Application No.: 21/03350/TEL

**Proposal:** Proposed 5G Telecommunications Installation

**Location:** Street Record

Station Road Kirtlington

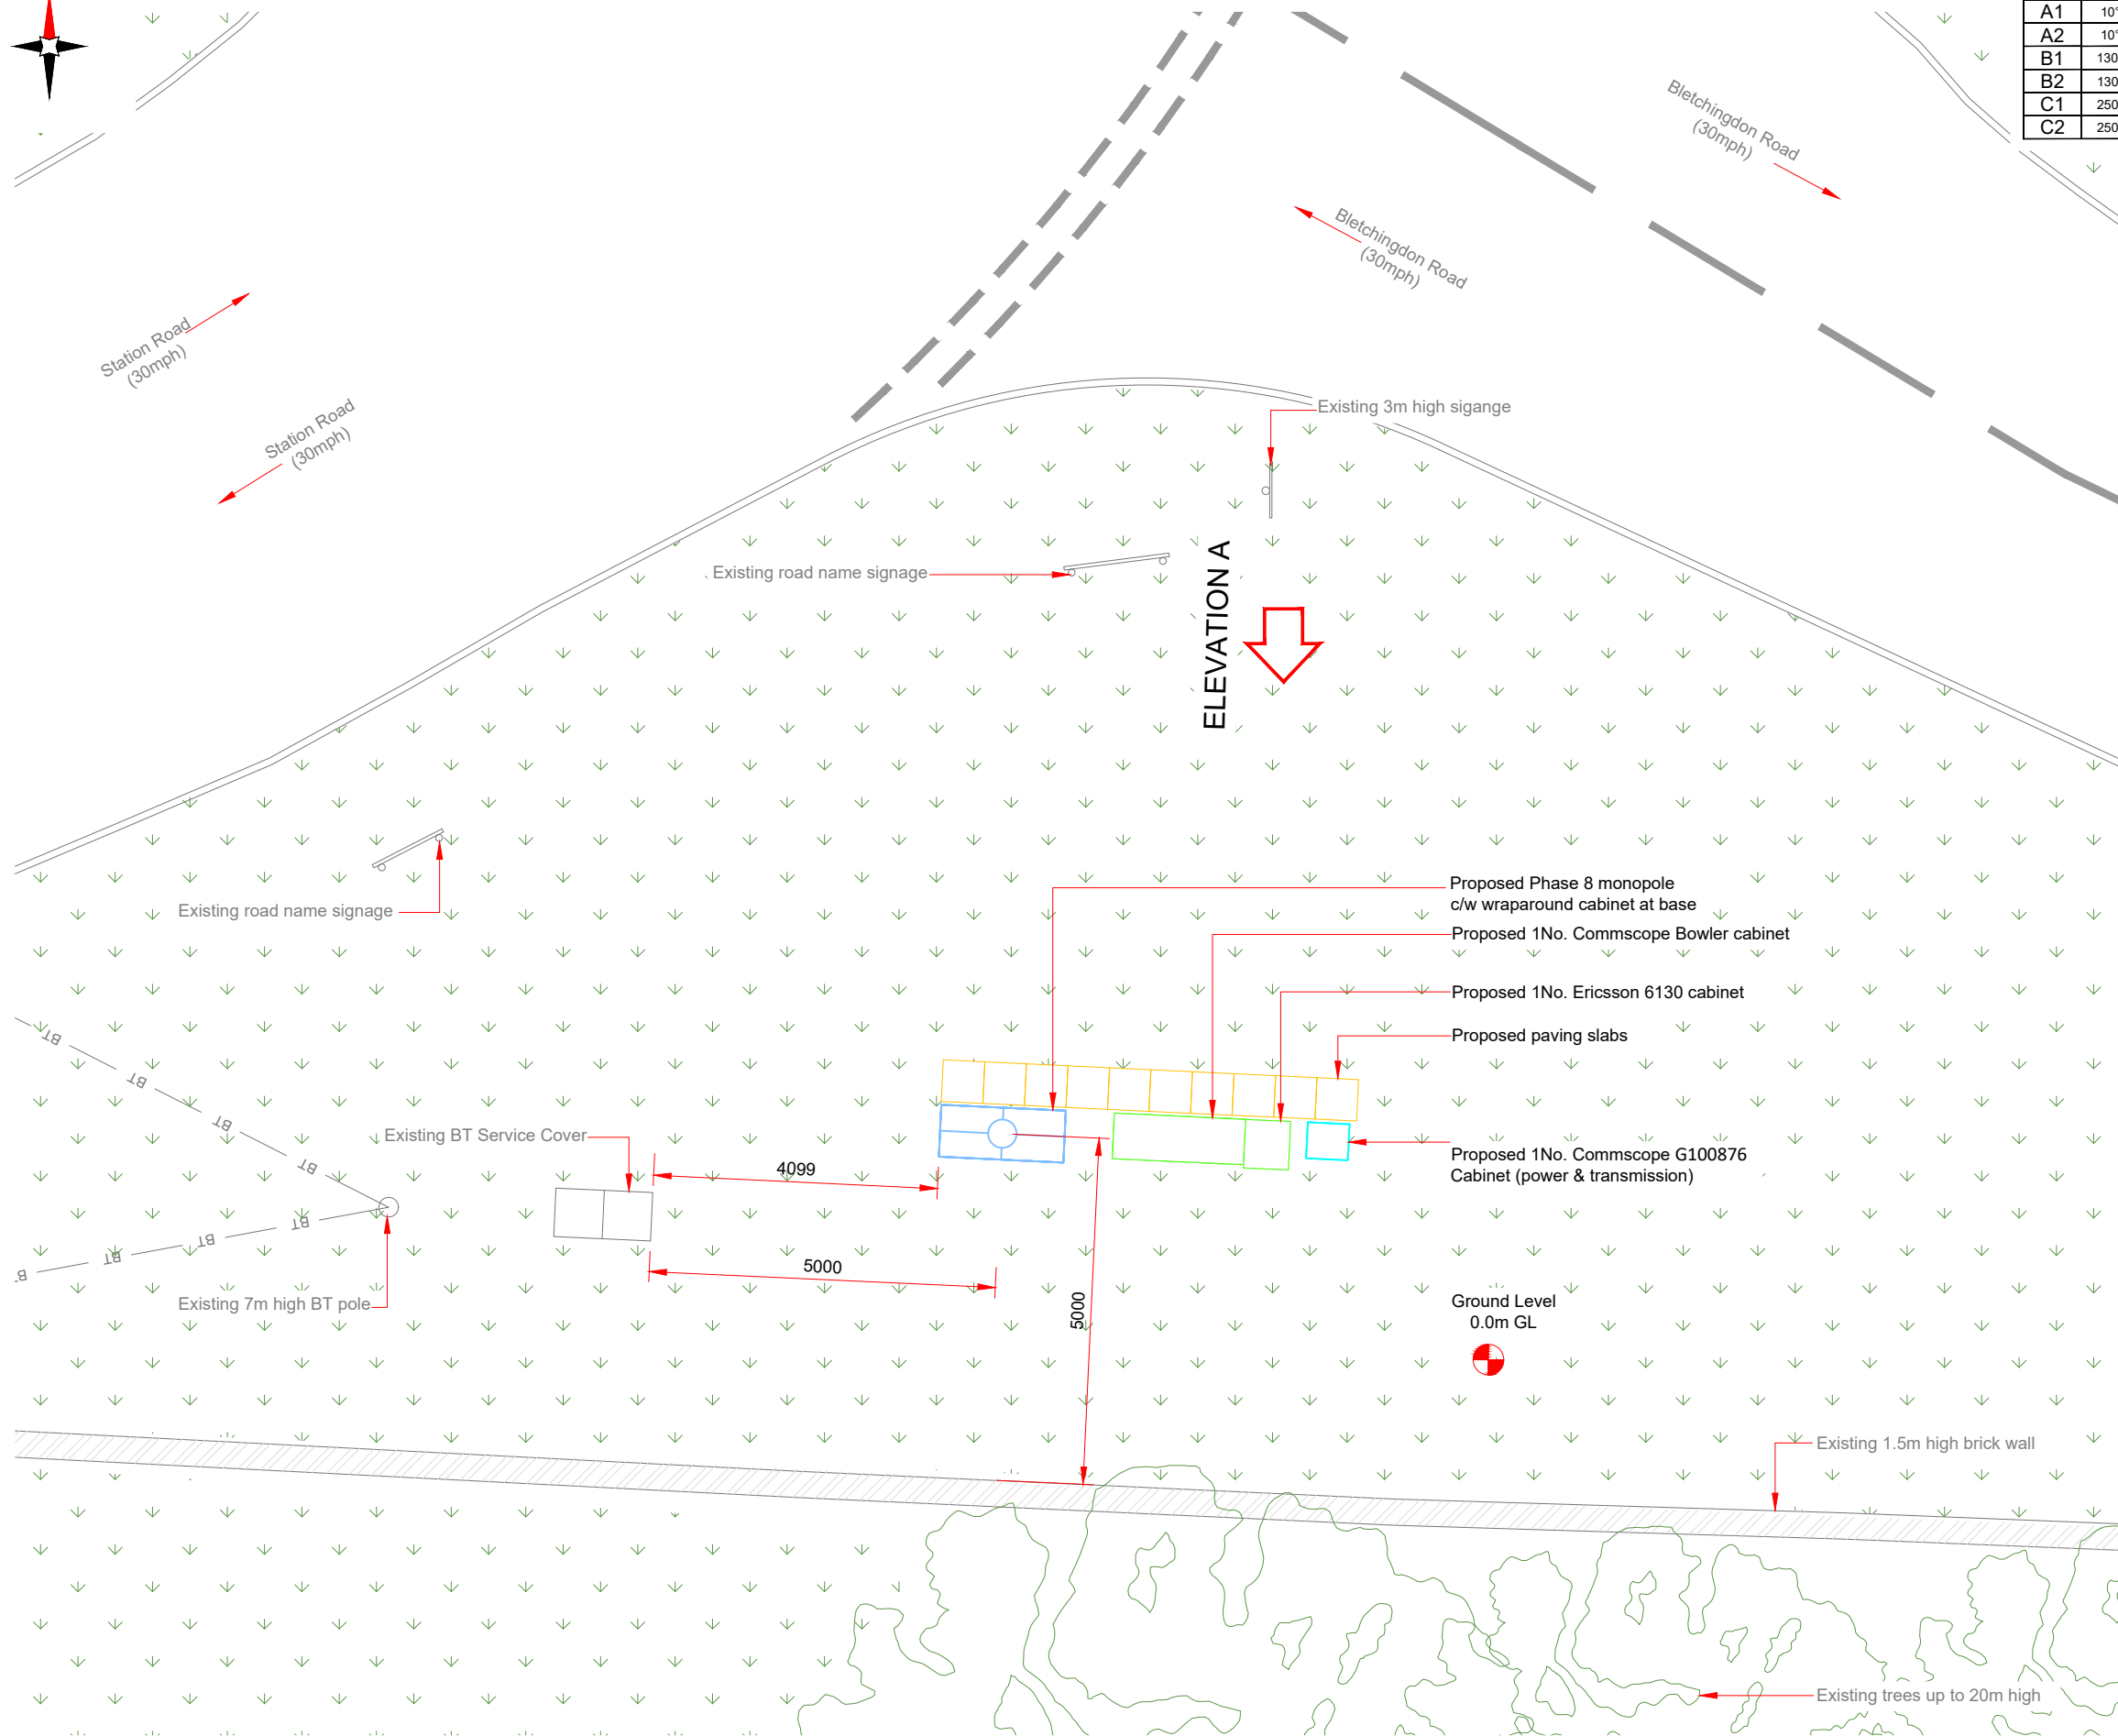
I write in response to the above application seeking the pre application views of the Council with respect to the proposed erection of a 15m monopole telecommunications mast together with a wrap-around cabinet at its base and with a further three cabinets alongside, which would be positioned on the highway verge south of the junction of the Oxford and Bletchingdon Roads in Kirtlington.

The site immediately adjoins the Kirtlington Conservation Area and the views from the Conservation Area to the North, East and West of the site would be detrimentally impacted by this proposal. This would significantly harm the heritage setting of the adjoining part of the Conservation Area by reason of the prominence of the location and height of the proposed mast, the resulting harm is compounded by the fact that the proposed works may undermine the existing stone wall which has a positive impact on the heritage asset and is itself considered to be a non-designated heritage asset, and that the proposed works may compromise the root protection areas of the adjacent mature trees on private land to the south of the site.

Title: **260 PROPOSED ELEVATION**

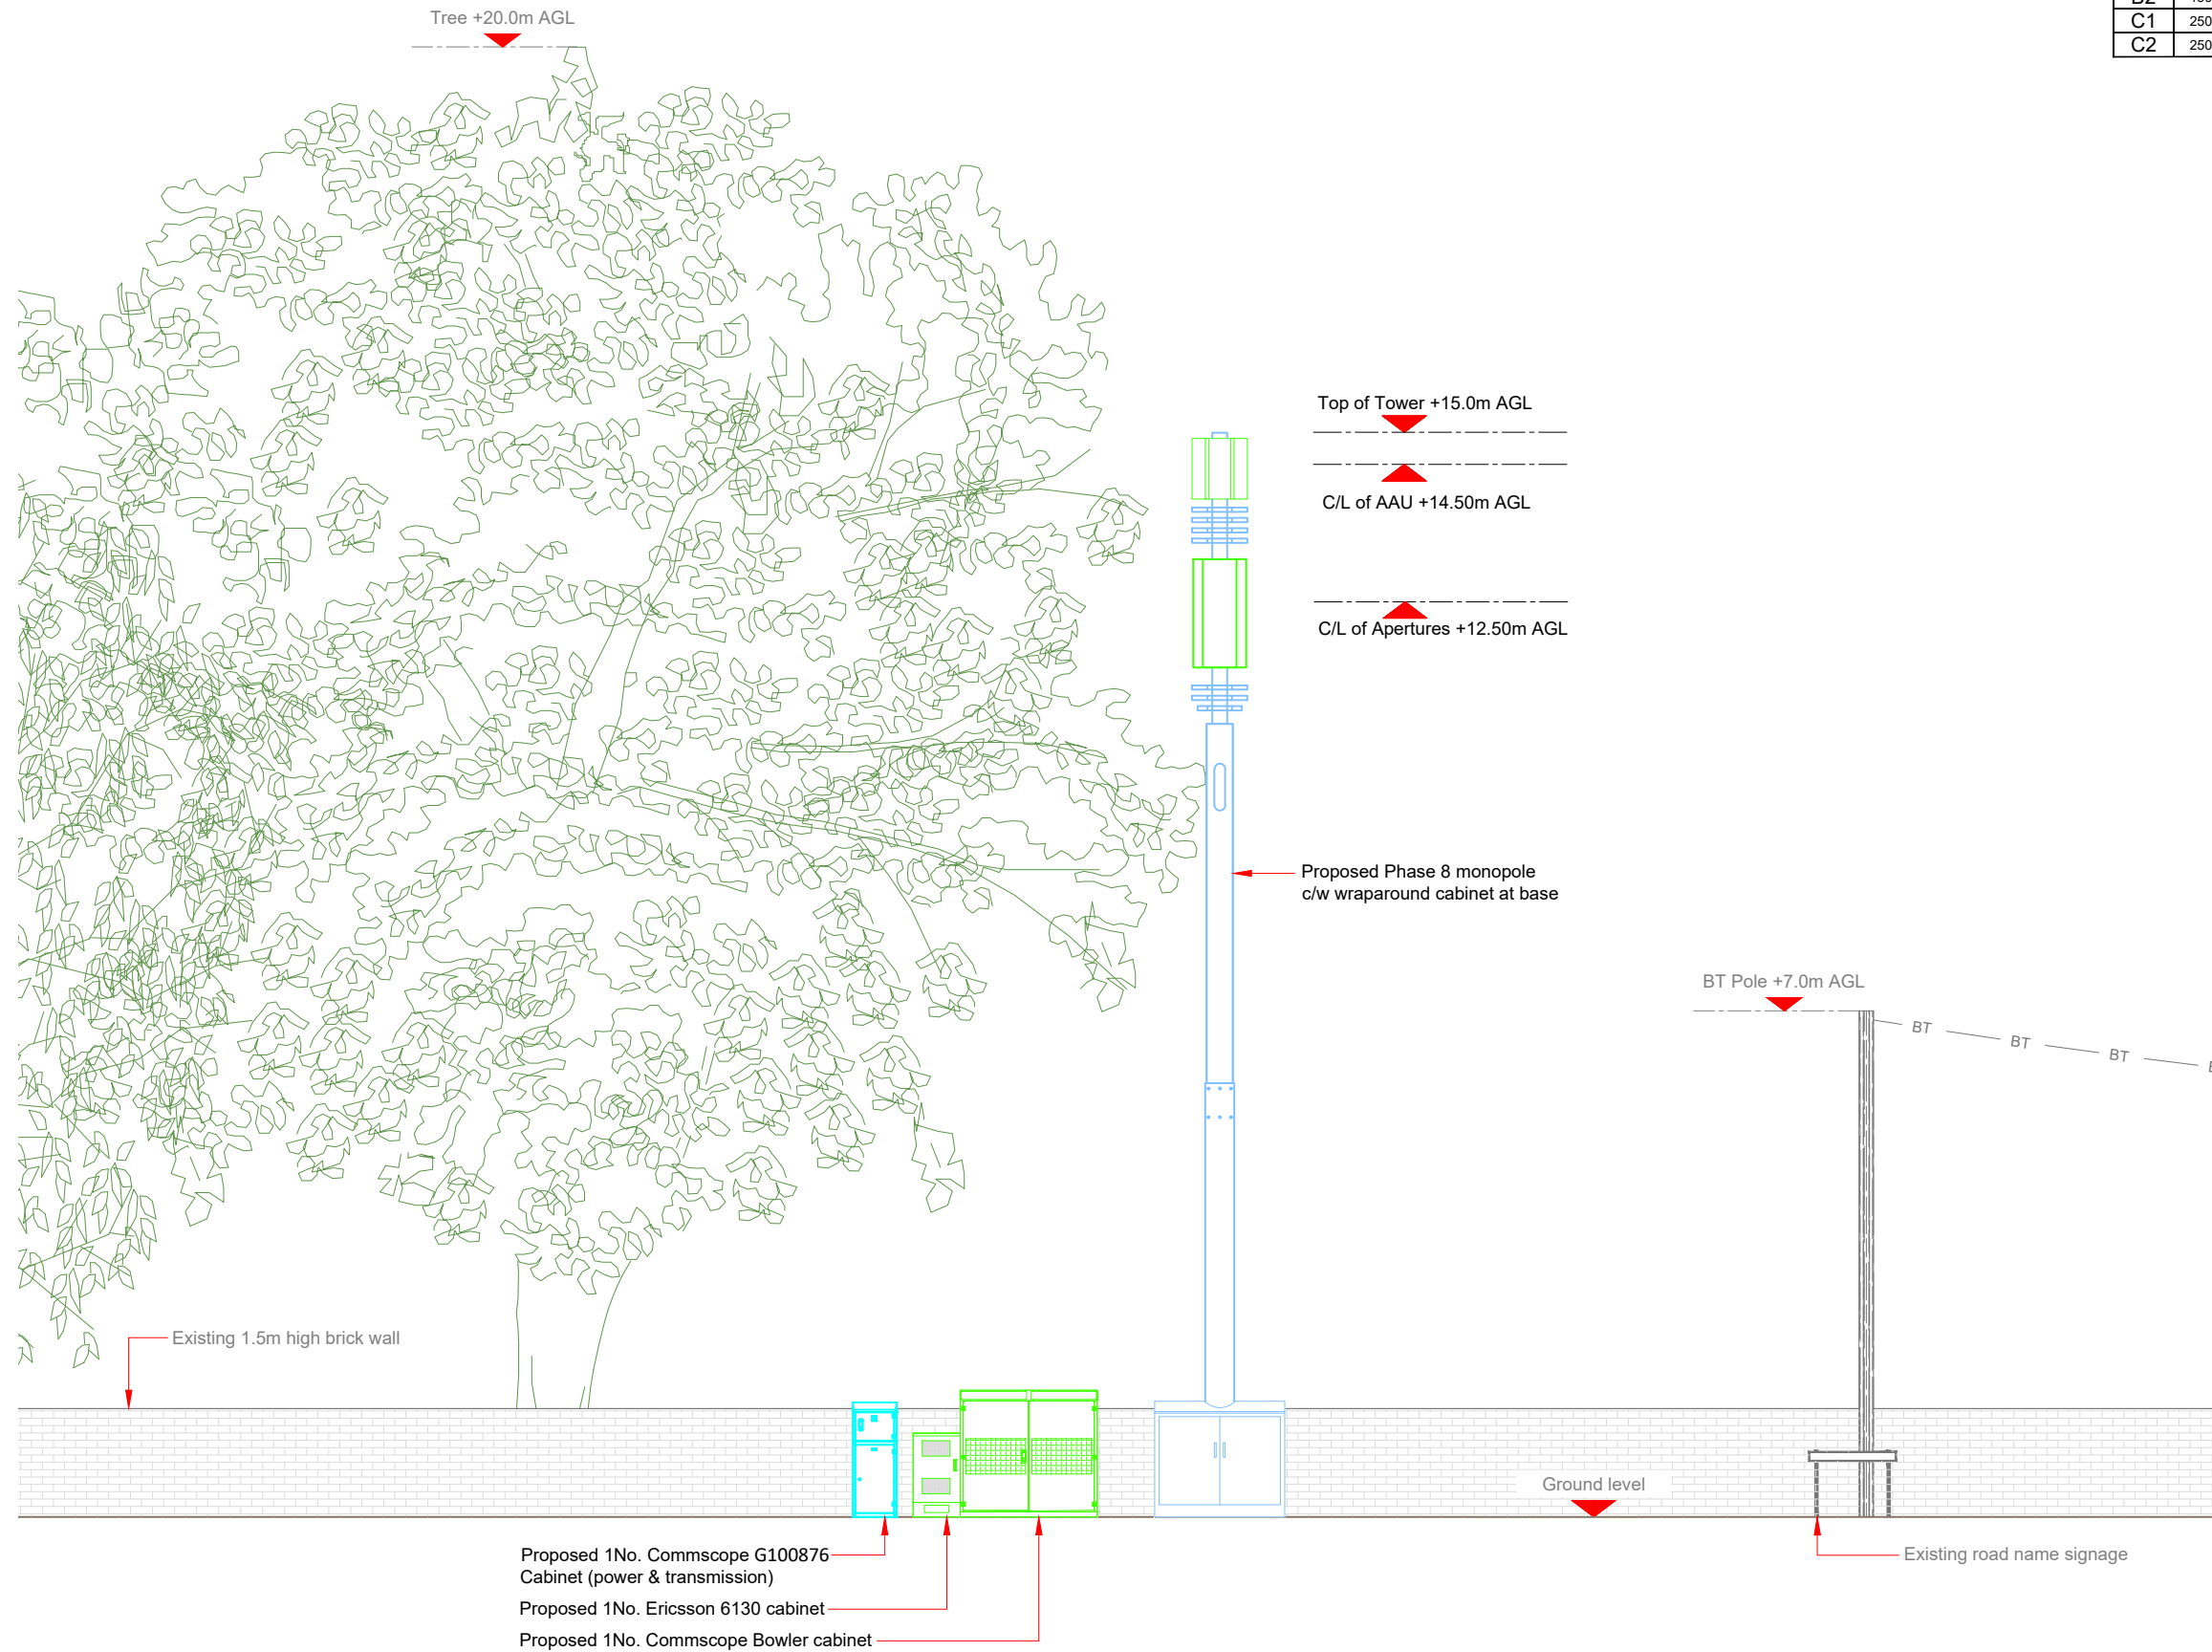
It is considered that the proposed mast would be a dominant an alien feature at this gateway to the village and would have a significant detrimental impact on the character and appearance of the Kirtlington Conservation Area, In view of this conclusion, I write for and on behalf of Cherwell District Council to object to the proposed siting of the above monopole mast and associated cabinets.
